DRB Application No.: 06DRB-00348 (P&F)
Project Name: ALVARADO GARDENS UNIT 2
Agent: Wilks Company

CITY OF ALBUQUERQUE
Planning Department
March 22, 2006
DRB Comments

PROJECT # 1003442 APPLICATION # 06DRB-00348

RE: Alvarado Gardens, Unit 2/p&f

PLAT OF
TRACTS A, B and C
ALVARADO GARDENS SUBDIVISION
UNIT No. 2

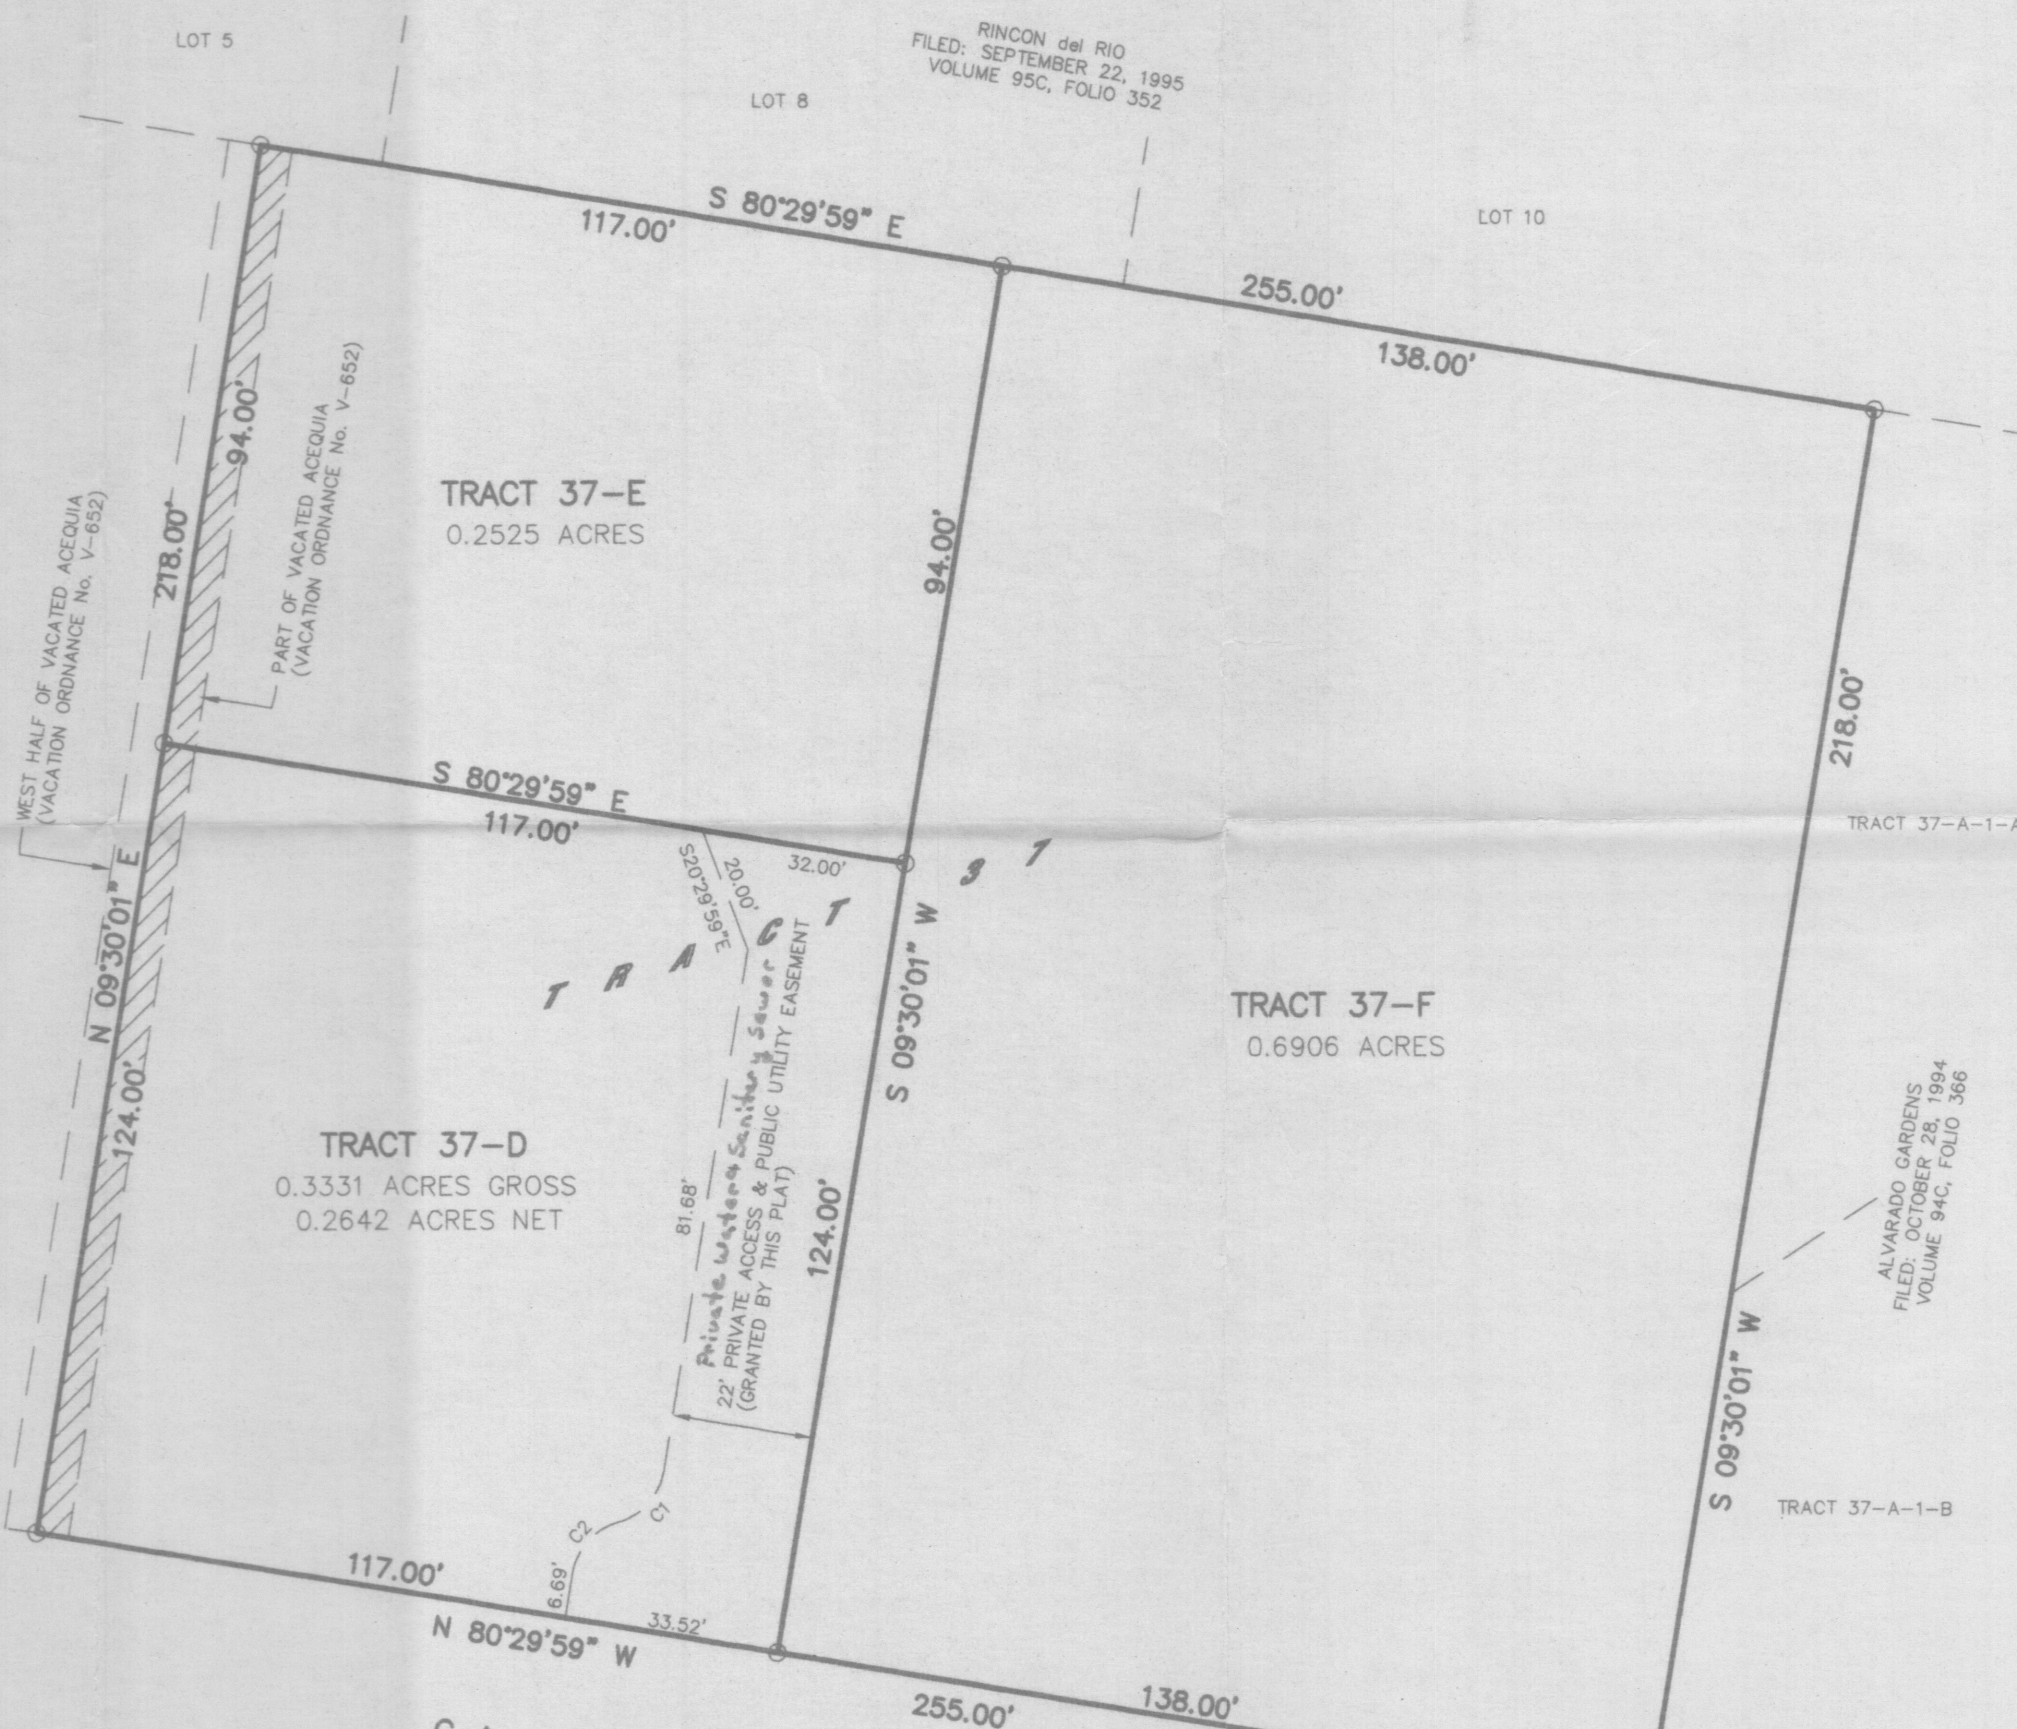
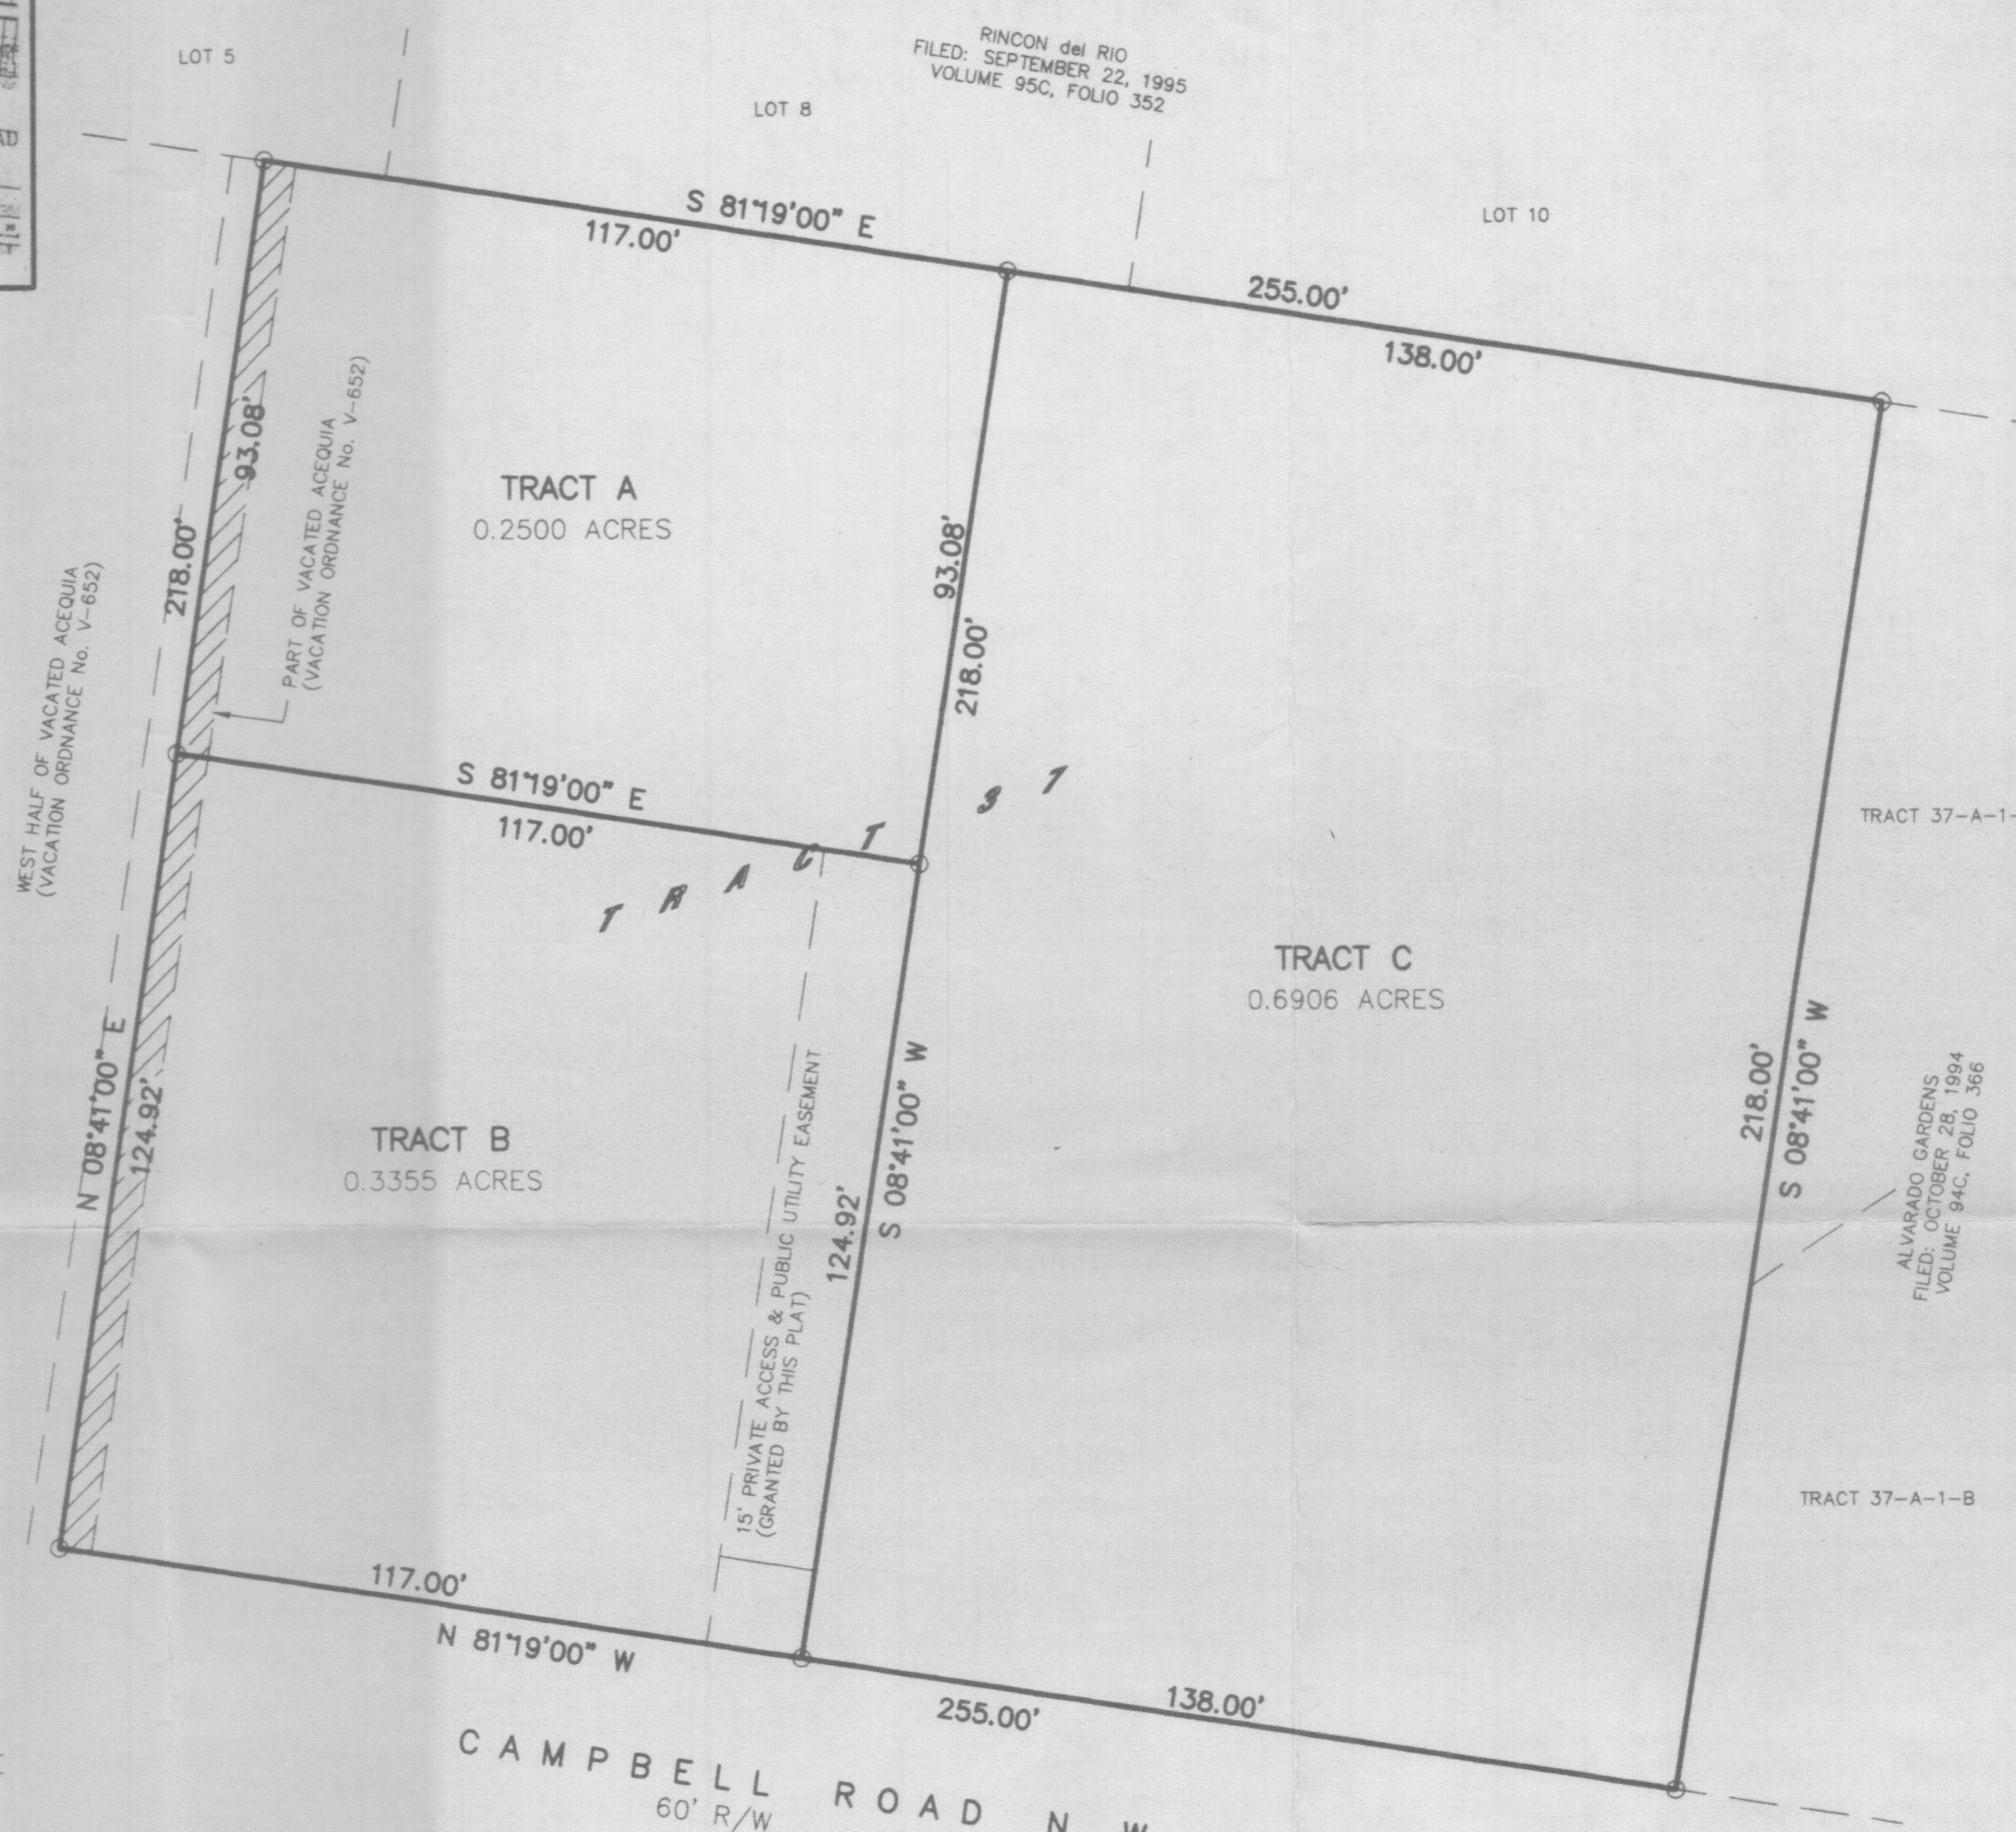
Are there any perimeter walls going to be placed on Campbell Rd? If so, the DRB Chair must pre-approve the design before signing this plat.
